Re: Planning Application R/94/19/PL Rustington Convalescent Home, Sea Road, Rustington.

I wish to strongly object to the above revised planning application in respect of alterations being made to the structures and siting of Block F and Block E.

1 : 500 @ A1
SHEET NUMBER
0028-PBA-ZZ-00-DR-A-900001 -G

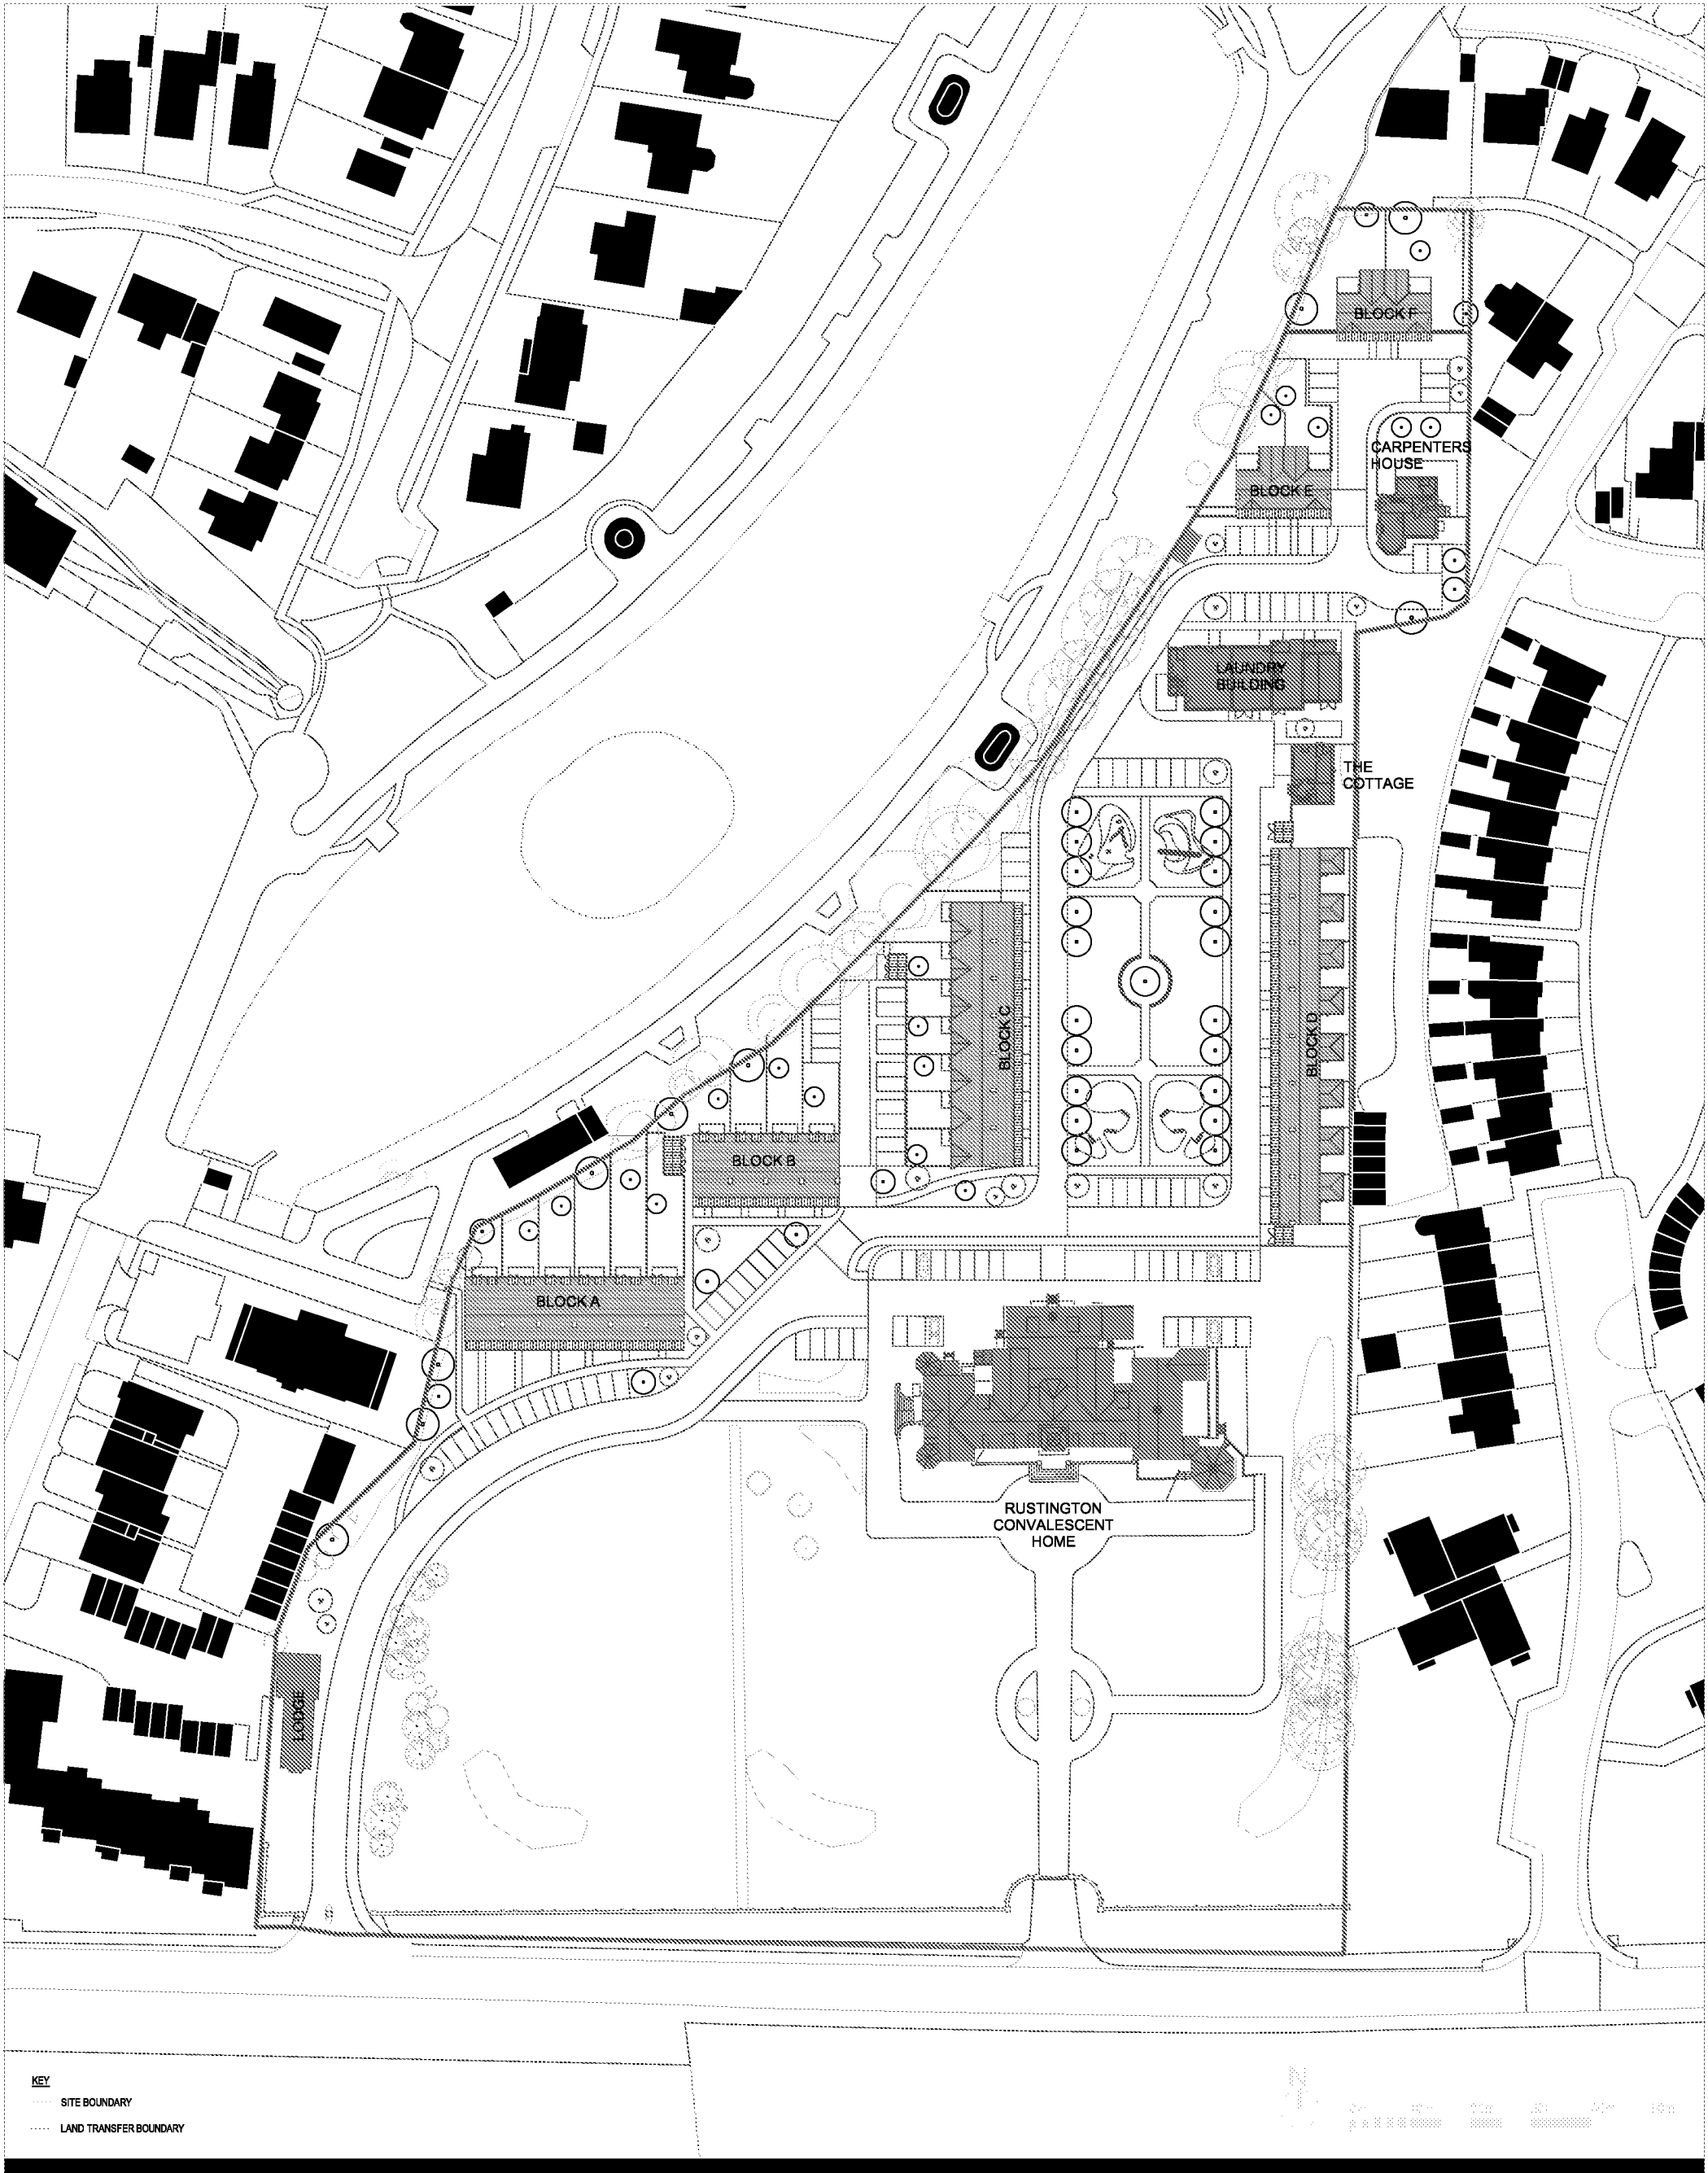
The latest plans propose to amend and change the said dwellings to full two-story height with windows over-looking straight into the bedroom windows of my house. The extra height I feel would restrict the daylight in my property and be very intrusive. The situation of Block F would almost cover the front view of 32 The Martlets. The site of the revised plans also appear the building is nearer to the boundary fence.

Having re-read the document "Design and Access statement: Rustington Convalescent Home February 2015," it clearly states (1.4) for Block D on the eastern boundary that "the back to back, habitable room to habitable room would have a distance of 25 metres". The latest plans do not show anywhere near the 25 metre distance from habitable room to habitable room in between Block F and the front lounge of 32 The Martlets. Also, the new plans are proposing to move Block D a further 1.5 metres away from the east border facing the crescent Martlets properties.

This appears to be blatant discrimination in respect of 32 The Martlets as the distance shows on the plans as approximately 21.0 metres apart. The property does not have a road, footpath or garages to shield the proposed new designed houses.
